**Your Ref:** OWPC26709  
**Our Ref:** A/54/20/HH 02-04-2020  
**Please ask for:**  
Zac Denton

Proposed conversion and extension to existing garage into ancillary accommodation, new driveway to front of property. This application affects the character & appearance of the Angmering Conservation Area.

Ariston Water Lane Angmering

HAPA ARCHITECTS			
Job Name			
Ariston, Water Lane, Angmering, Littlehampton			
Status	PLANNING	Drawing Type	PROPOSED SITE PLAN/ BLOCK AND PROPOSED GARAGE CONVERSION PLAN AND ELEVATIONS
Date	APRIL '20	Scale	1:50, 100 & 500 @ A1
Job Ref			WL_101
Drawing Number			L-200a

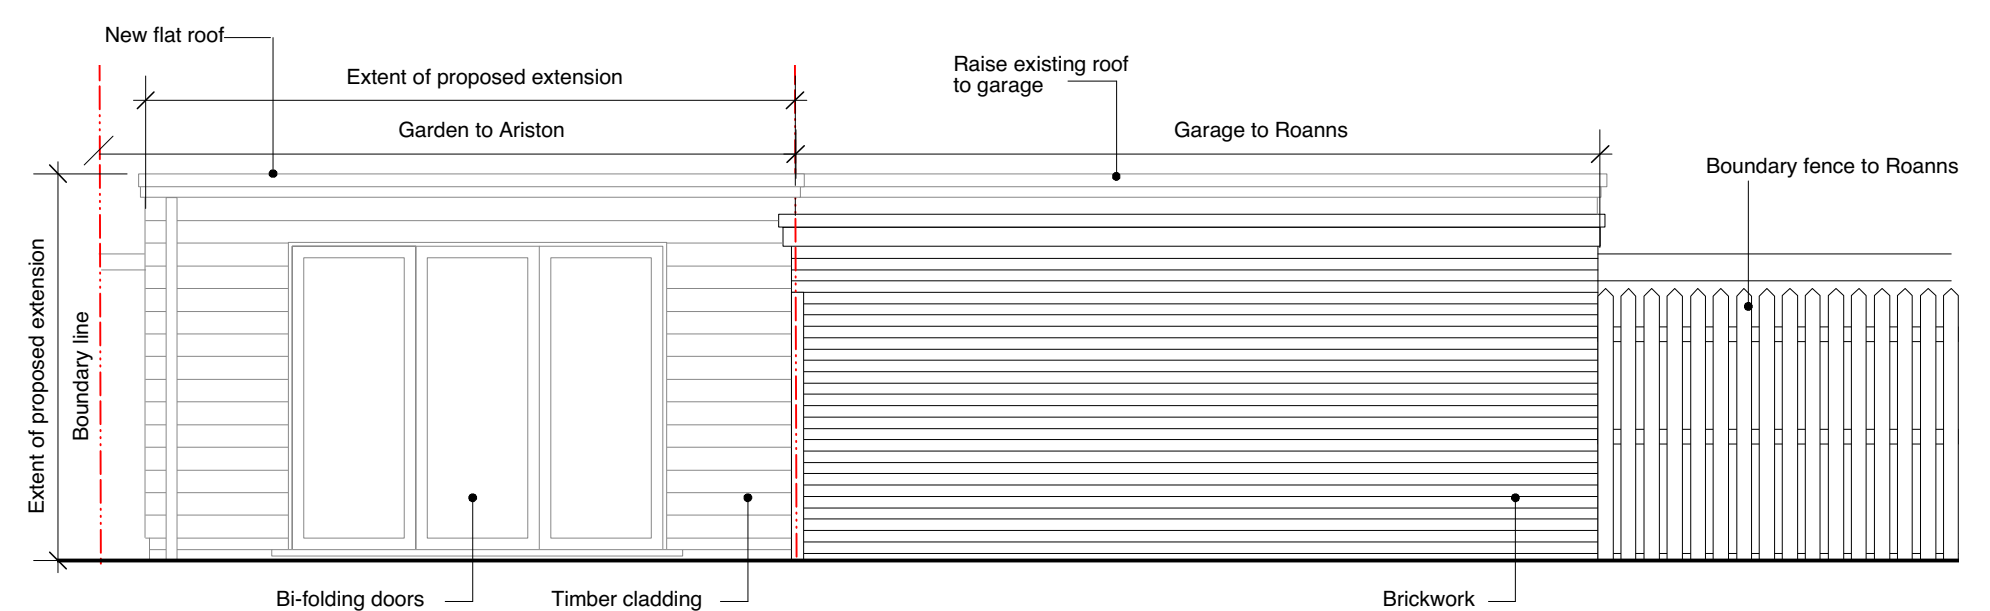
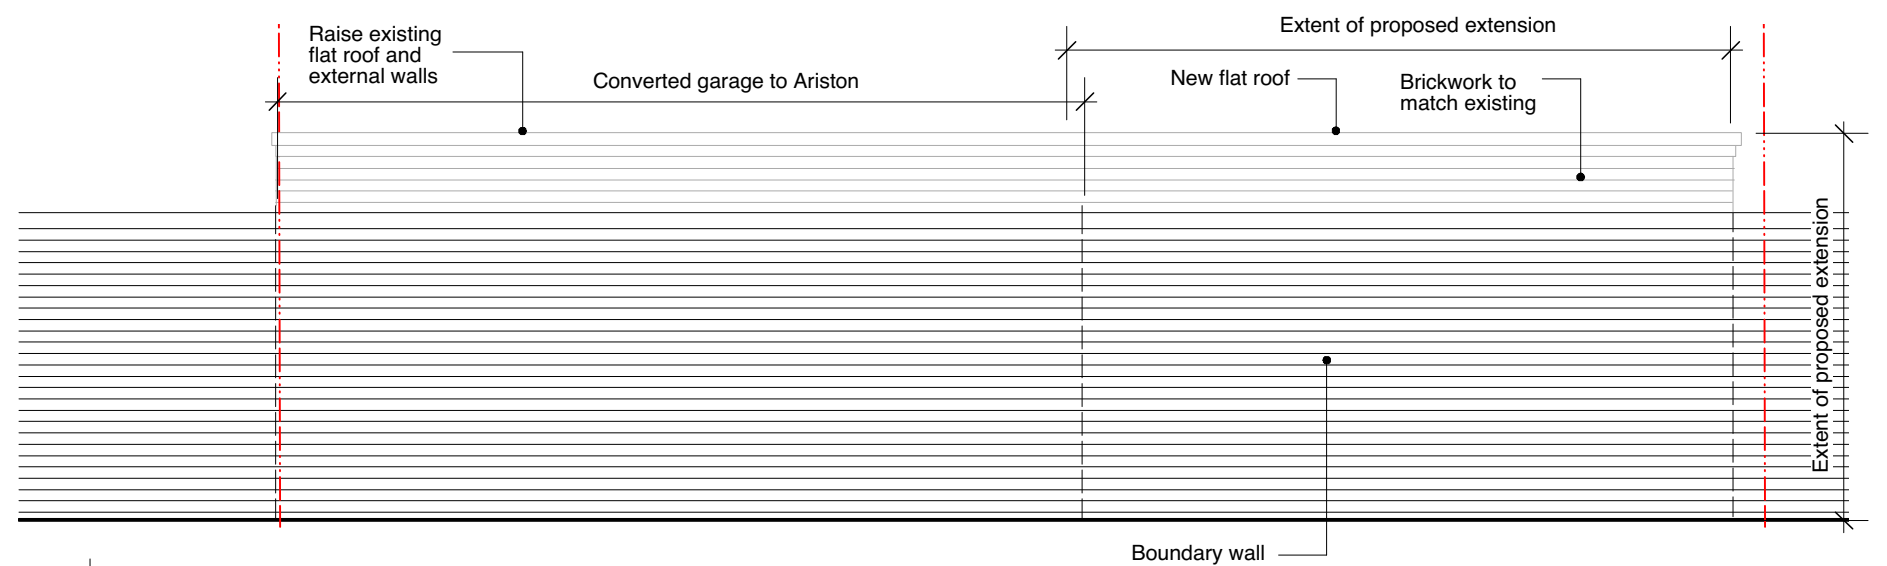
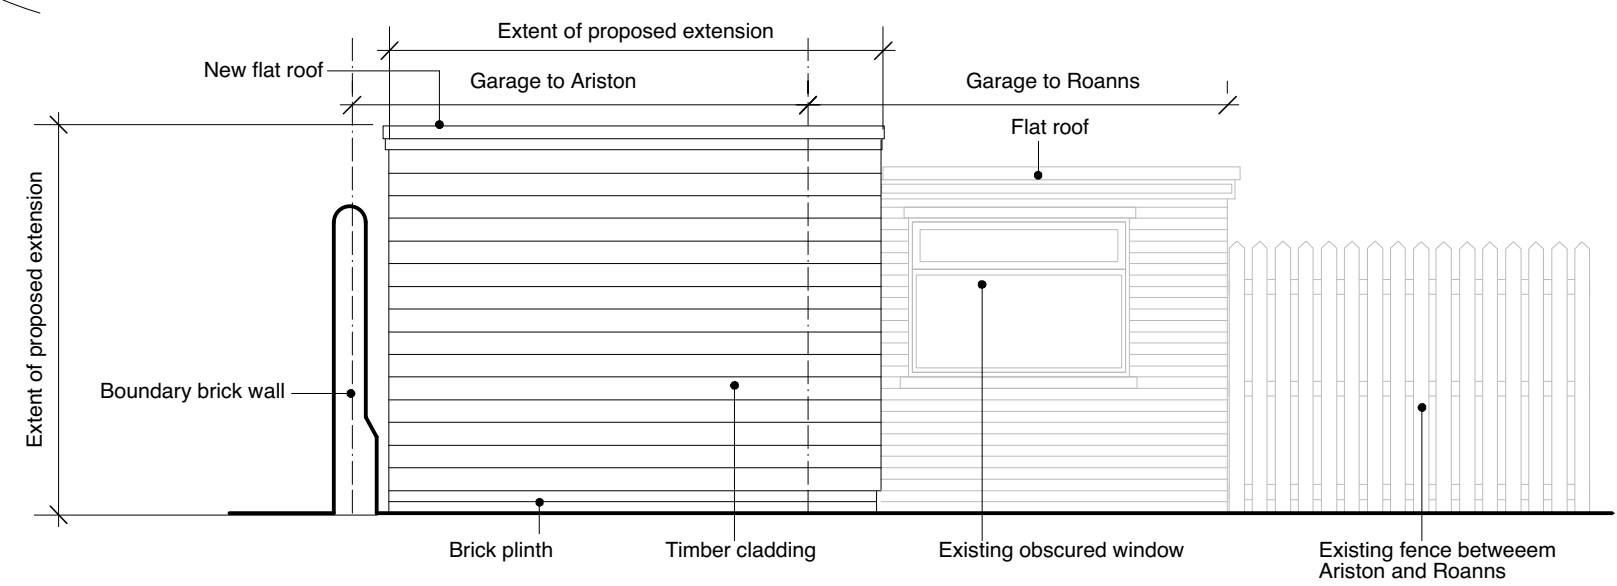
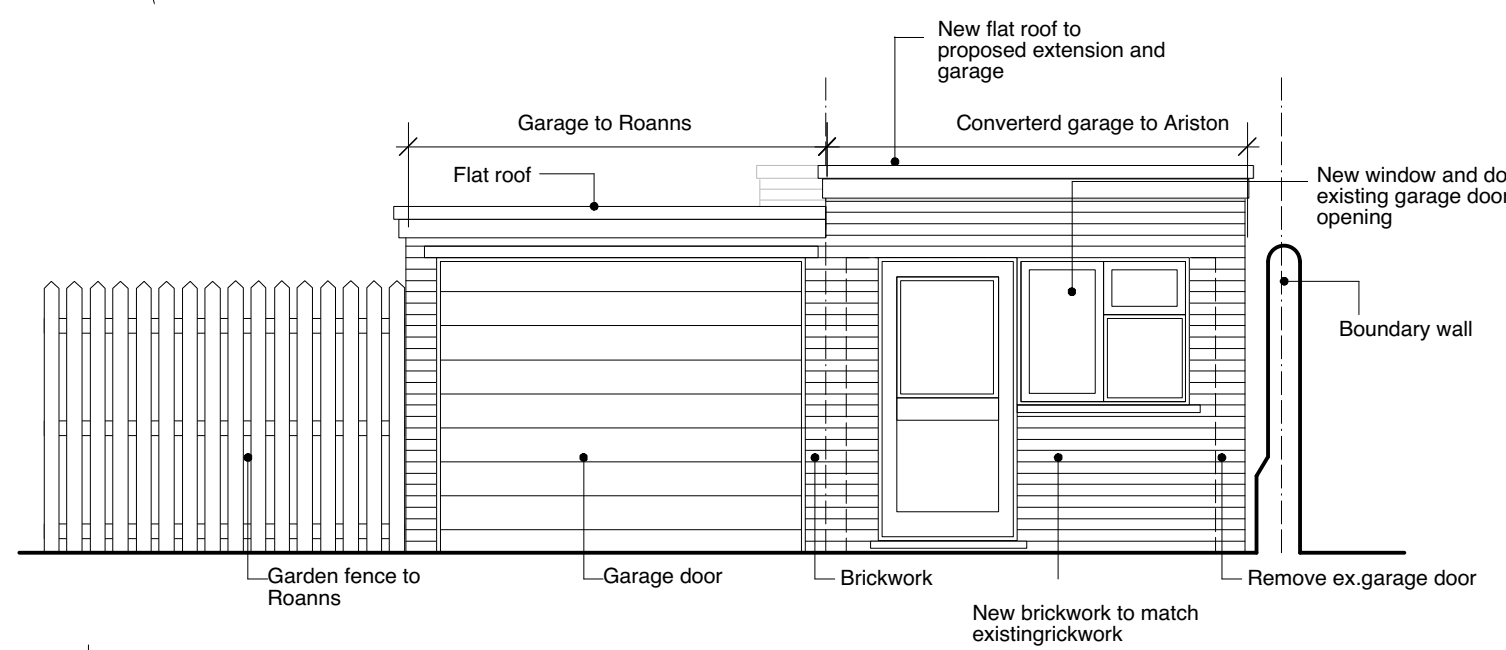
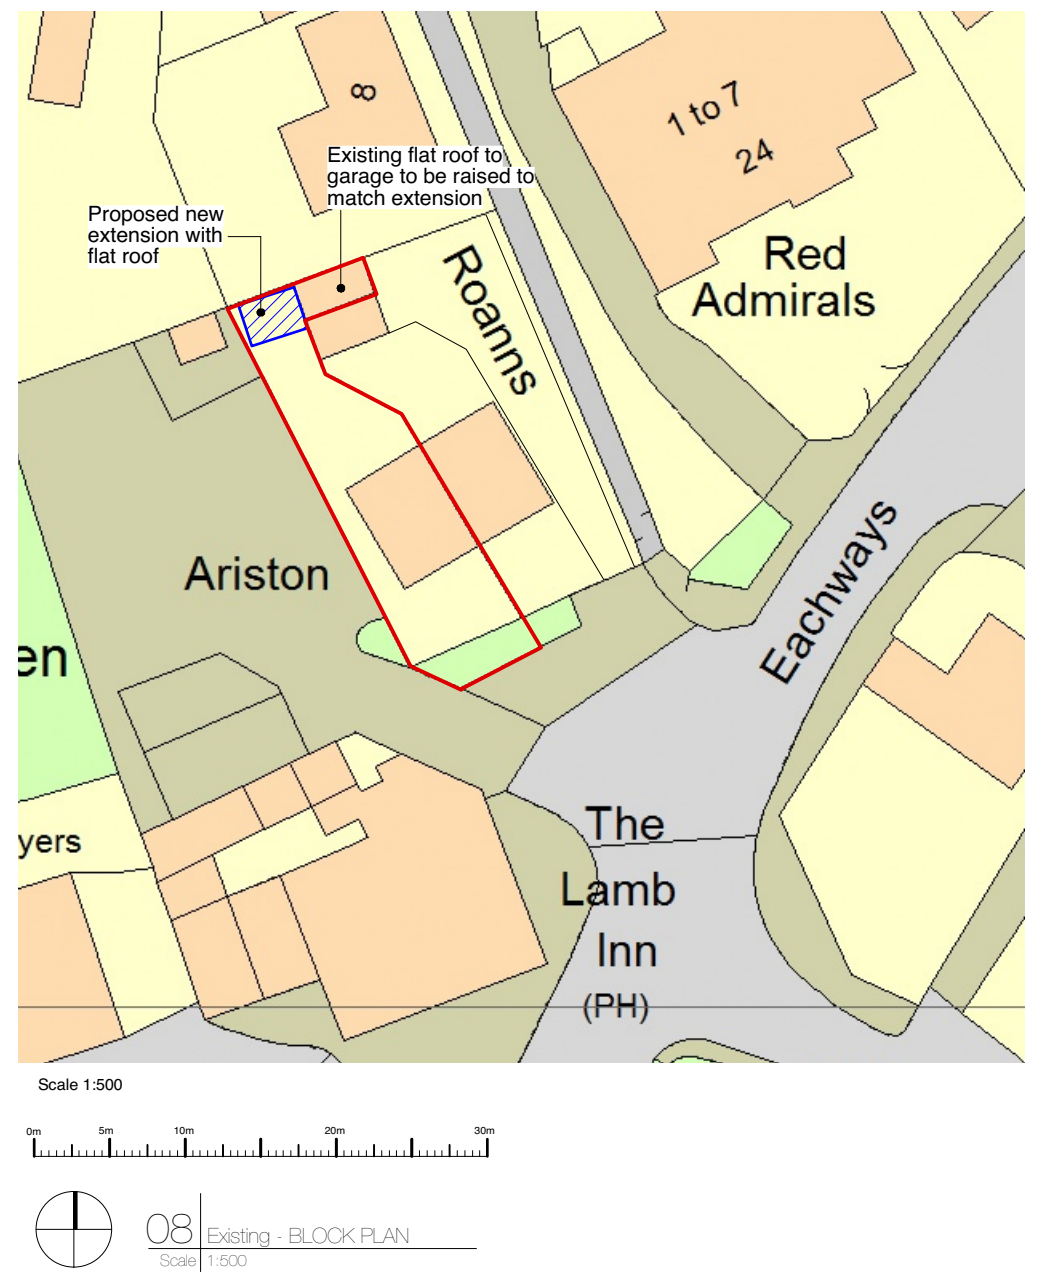
*4. The plans do not mention creating a firewall between the proposed ancillary building and the adjacent garage owned by Roans, nor do they show electric, water and waste arrangements.*

*Until more detailed plans are submitted that provide evidence that a firewall will be created and appropriate arrangements made for electricity, water and waste that do not impact upon either the garage belonging to Roans or the site belonging to Roans, I object on the grounds that insufficient information has been provided to allow for an informed decision.*

*5. The submitted plans do not include sufficient detail to provide confidence that the integrity of the garage owned by Roans, and attached in whole to the garage owned by Ariston (that is to form the substantial part of the newly created ancillary accommodation) is protected. I can see no mention in any of the submitted planning application documents that suggest that the applicant gives a commitment to undertake any works required to maintain that integrity and make good any damage or deficit caused through the construction.*
